Planning Application Ref: FG/170/20/T

Location: Verge opposite 18a Ocean Drive, The Poplars, Ferring, BN12 5GJ

Description of works: Various works to 6no. Austrian pine trees

Plan showing location of trees

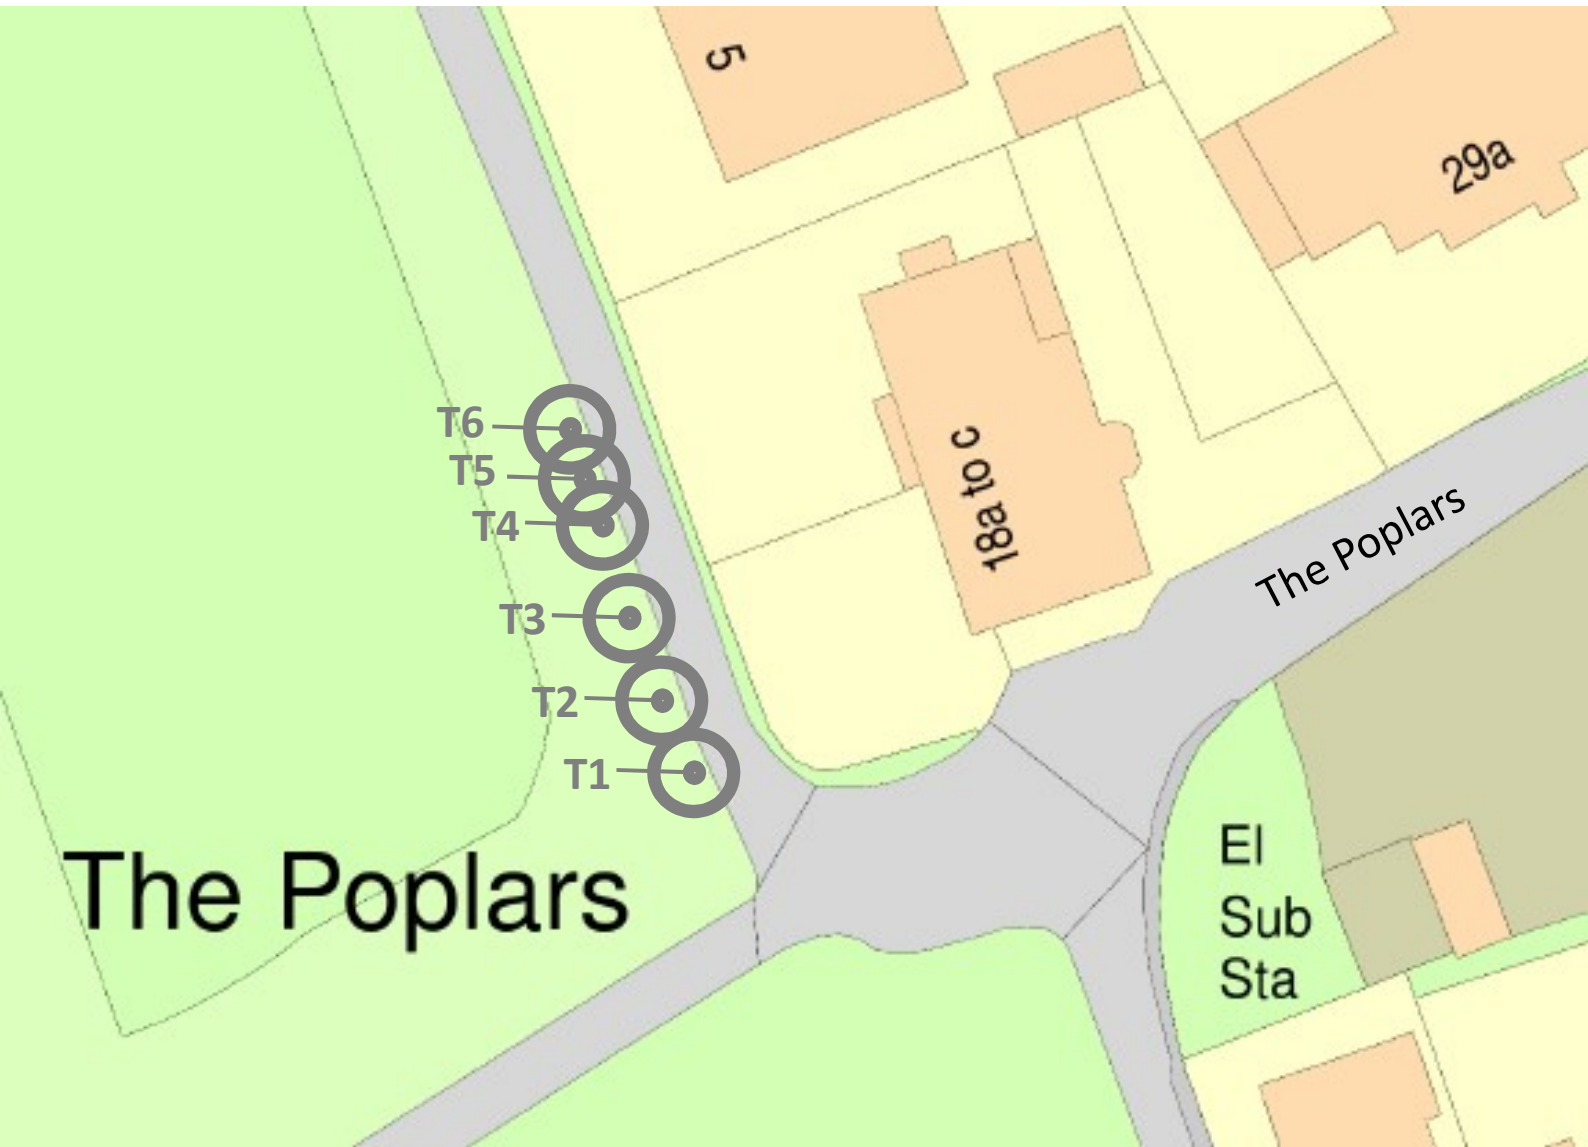
T1 & T2 - The bulk of property overhang arises from these trees. Crown lifting to 5m could pave the way for excessive reduction of lateral spread (to achieve the proposed overhead clearance), resulting in unacceptably large wounds being created. The stated reduction of lateral spread from 8m to 5m is excessive and likely to result in decline of individual branches.

T3 - There is no growth below 5m ht. or significant overhang from the tree's east aspect.

T4 & T6 - Both trees are heavily suppressed by their companions and not obvious candidates for the work proposed.

T5 - Low branches are present (below 5m ht.) and could be removed without detriment to the amenity value of this tree. Property overhang is proportionate and should remain.

- These trees require careful management that respects their age and vulnerability to environmental changes and disease progression.
- The applicant proposes 2-3metre reduction of lateral spread for several trees. If the full extent of meterage is applied, that would exceed the recommendations in British Standard 3998:2010 – Tree Work and cause decline in some of those limbs/branches.
- The trees are a significant feature in the local landscape and appear to be in adequately sound and healthy condition. The tree surgery proposed in the application could result in undue detriment to the visual amenities of the locality.

T1 & T2 - Reduce radial spread by no more than 1.5m. In any event, a minimum of 7metres lateral spread when measured from the main stem must remain. Crown lift by removal of/reducing small diameter branches (<100mm) to achieve a maximum of 4metres overhead clearance.

T5 - Crown lift by removal of/reducing small diameter branches (<100mm) to achieve a maximum of 5metres overhead clearance.
